***Submission on the Development Application,
Environmental Impact Statement (EIS) for the
State Significant Development Application for the
Redevelopment of the Australian Technology Park
(ATP) (SSD 7317)***

Desley Haas and Family
29 February 2016

Figure 9 – Building 1 (foreground in white) and Building 2 (background in white)
 Source: FJMT + SISSONS Architects

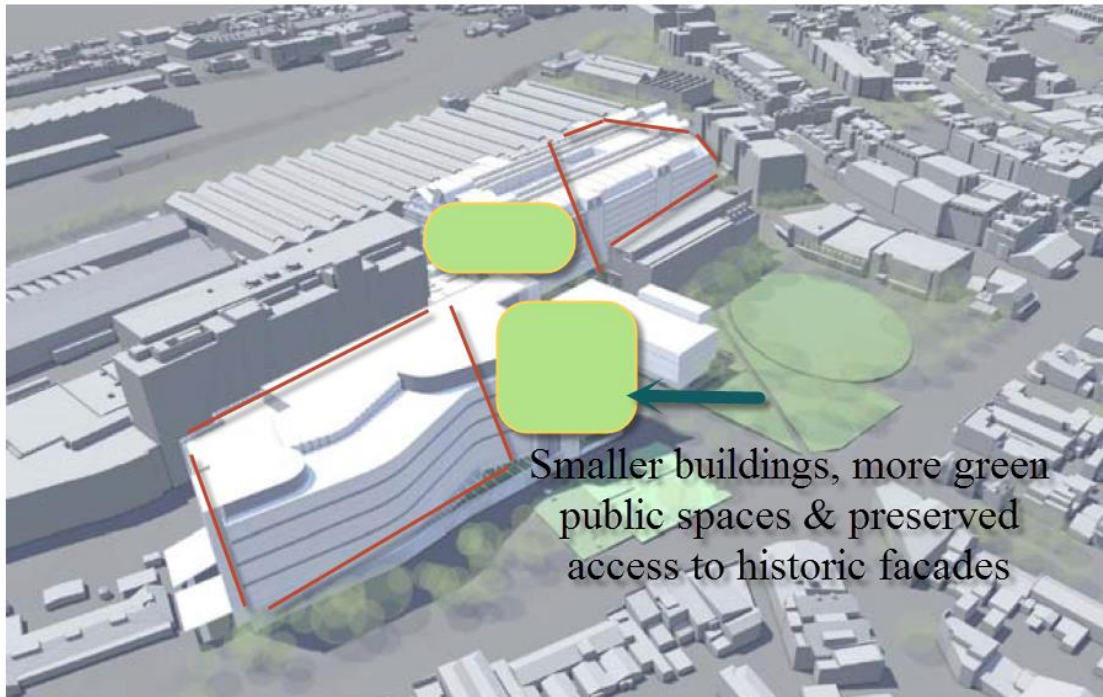
8. The *EIS* does **not** analyse nor detail justification worthy of approval for the proposed building height in the context of the adjoining development and height controls, especially with the increase from 4 stories to 9 stories for Building 1.

After all the time, work and effort the community invested in BEP 1 and 2 and the promises of the NSW Government it is completely unacceptable to see no set back of 4 stories, on Building 1. as agreed.

7. The size, bulk, height and locations of Building I and Building 2 will have serious impacts on the heritage buildings, the view lines, the existing public domain, and the residents and residents' homes that the buildings will be looming over and over-shadowing.

Figure 2 – Illustration of height distribution across ATP (with proposed variation circled in red)
Source: *fjmt*

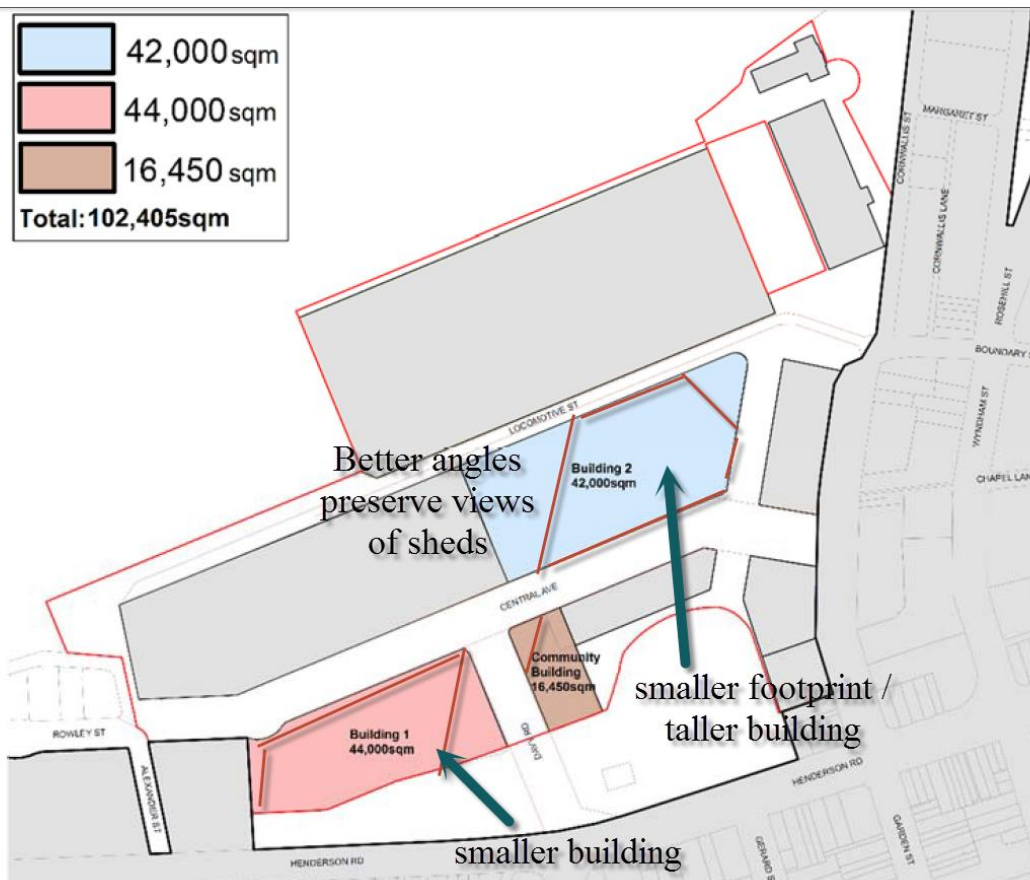
9. We **strongly object** to any variations or increases in heights, GFA, etc being granted to Mirvac.

Building 2 is already a whopping 35% above the accepted maximum GFA allowed under the MD SEPP. Building 1 is 6.4% above.
